**KIRKLEES METROPOLITAN COUNCIL
INVESTMENT & REGENERATION SERVICE**

**DELEGATED DECISION TO DETERMINE APPLICATIONS FOR
NON-MATERIAL AMENDMENTS**

Reference No: **2023/NM/92773/E**

Description: Non material amendment to previous permission
2019/91657 for erection of 30 dwellings

HOUSE TYPE C2 - STATION ROAD, SKELMANTHORPE

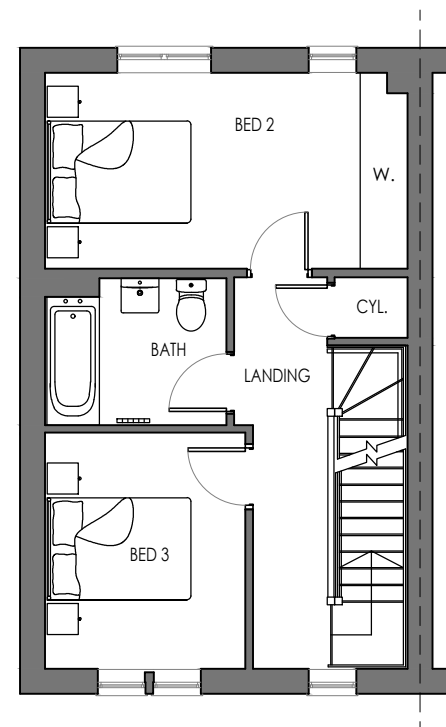
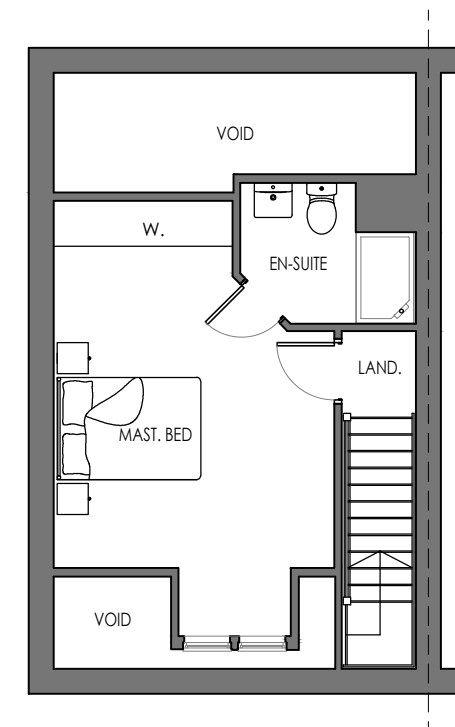
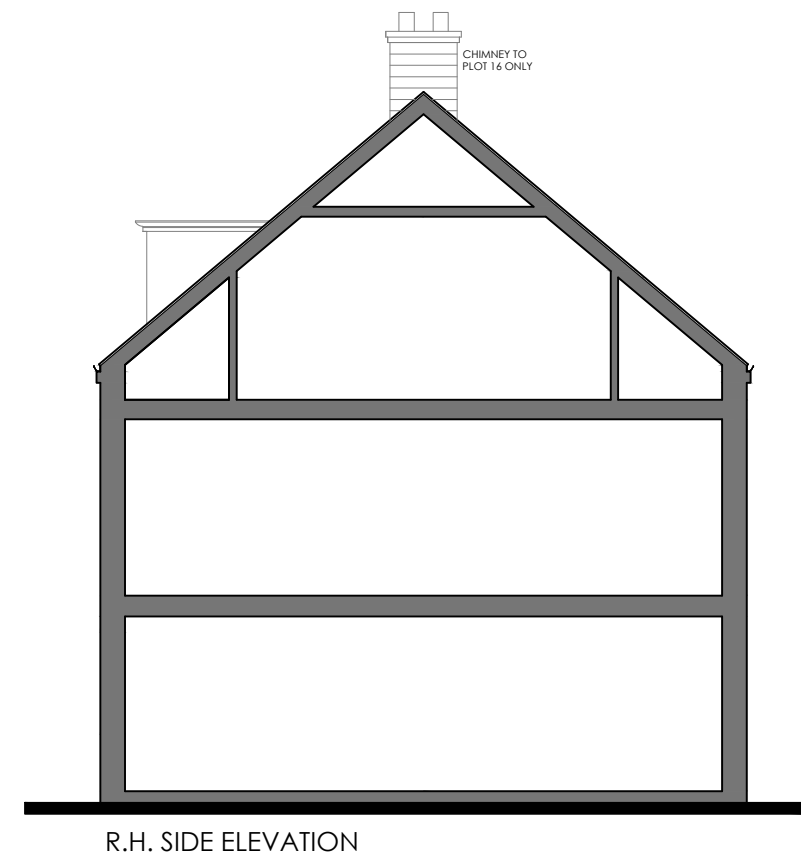
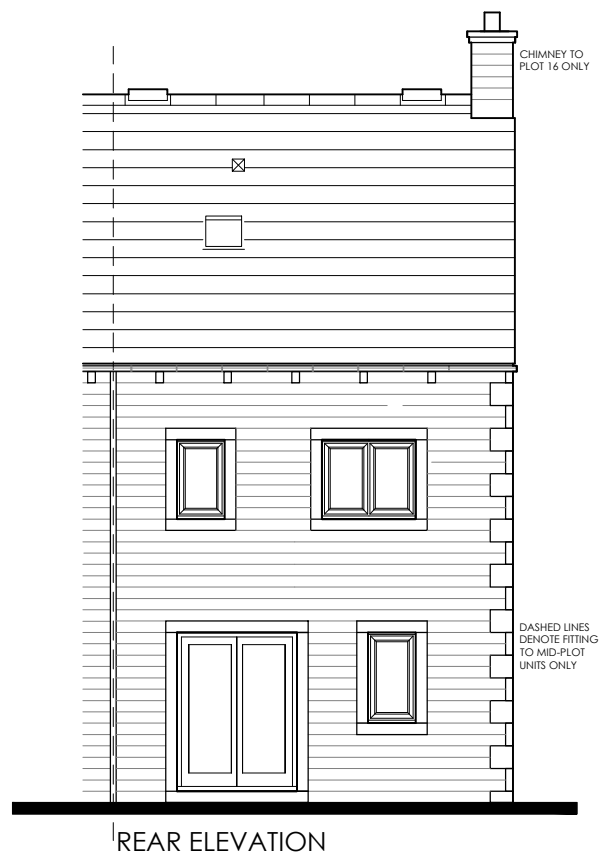
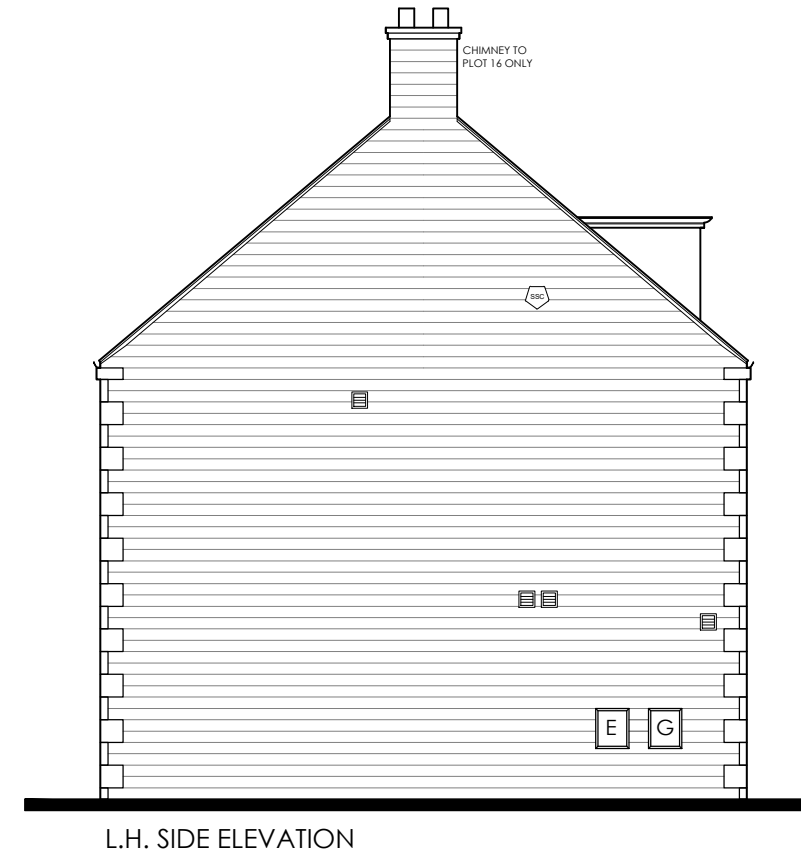
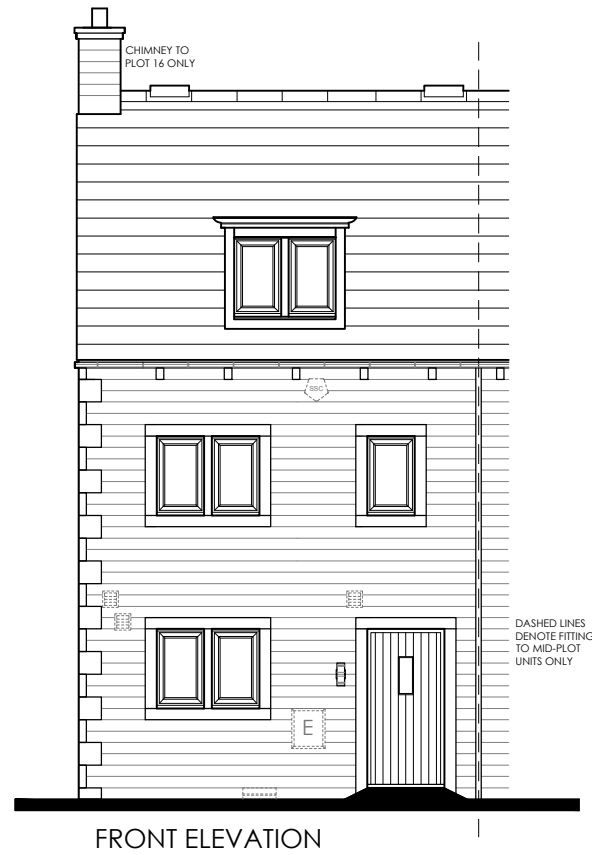
- Plots 16-18 (C2 type) – rear bifold door replaced with French door and window.
- Plot 28 (E type) – rear bifold door replaced with French door.
- Plots 19-22 (F type) – rear bifold door replaced with French door and side lights.
- Plot 25 (K type) – single-storey rear projection removed, window and door positions amended (also shown on site layout plan).
- Plot 26 (N type) – triple bifold door replaced with quad bifold door, and French doors to lounge replaced with triple windows.

The proposed changes would relate to fenestration and the deletion of a single-storey rear projection. These are considered to be minor amendments which raise no significant concerns in relation to planning matters. The removal of some of the front ground floor windows from unit 25 would result in an asymmetrical front elevation, however this is not a significant concern given the relative location of that dwelling's detached garage. The reduction in the size of unit 25 does not raise concerns regarding the Government's Nationally Described Space Standards (March 2015, updated 2016).
